OXFORDSHIRE COUNTY COUNCIL'S RESPONSE TO CONSULTATION ON THE FOLLOWING DEVELOPMENT PROPOSAL

Application no: 23/00915/F

Proposal: : Planning Application for Development within Use Classes E(g) (i), and/or (ii), and/or (iii), and/or B2 and/or B8 and associated works including access and parking (relating to proposed Buildings 8, 9, 10 and 11)

Location: Buildings 8-11, Oxford Technology Park, Technology Drive, Kidlington, OX5 1GN

content : BUILDING 8, 9, 10 & 11
PROPOSED CYCLE LOCATIONS

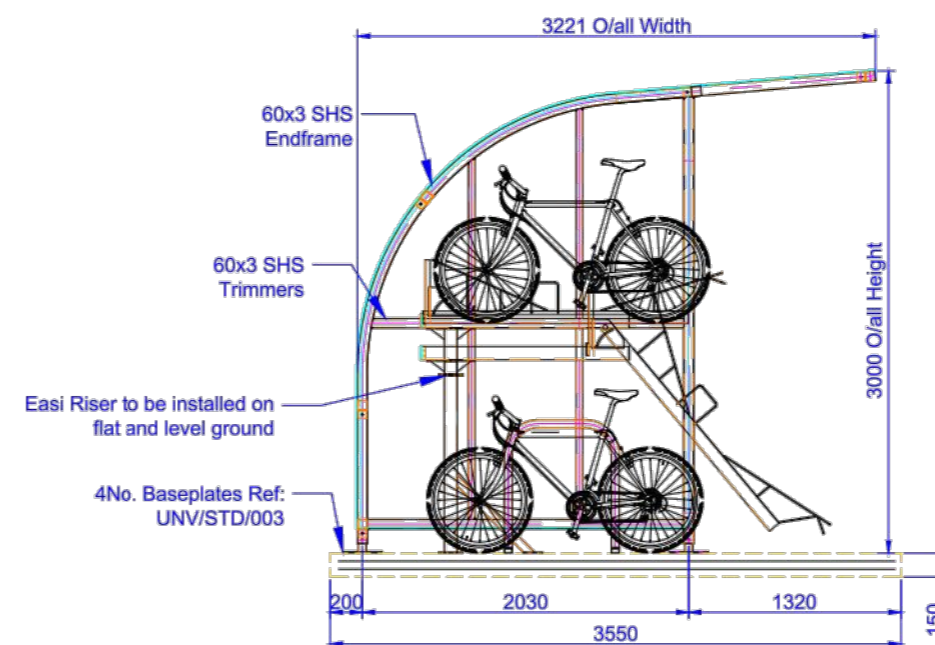
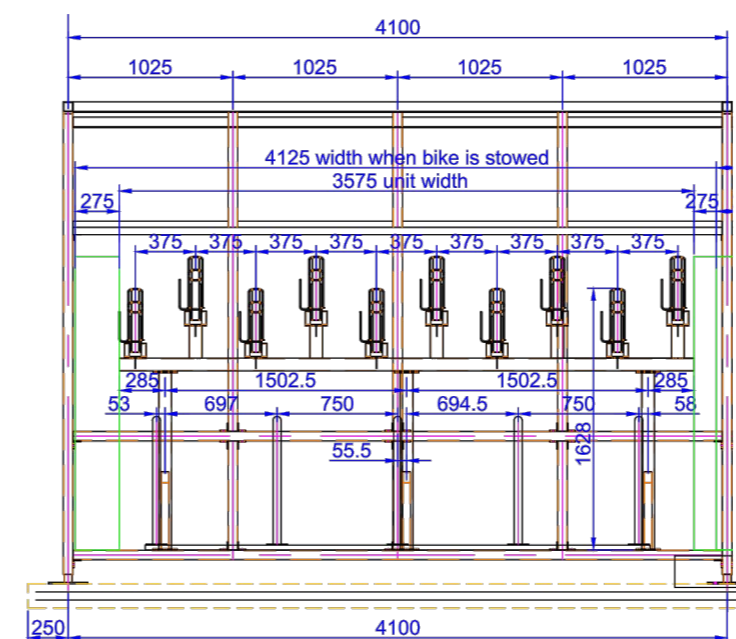
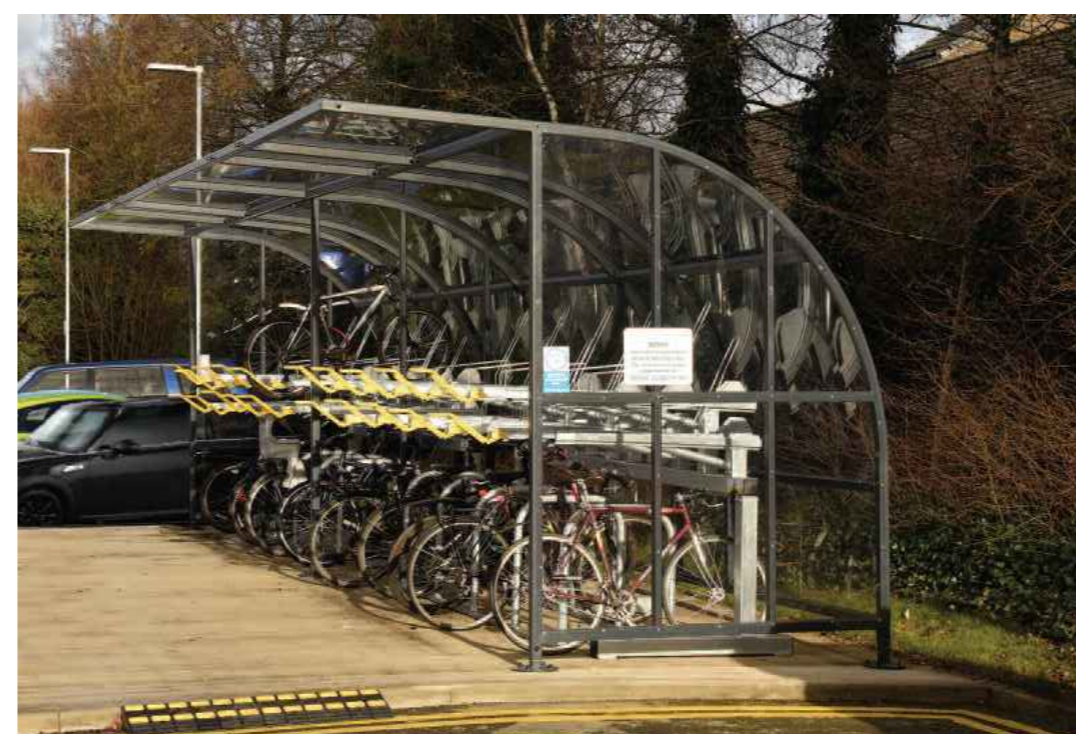
The provision for cycle parking follows that for the existing and permitted units and the level of cycle parking proposed is acceptable taking account of the likely use of the development.
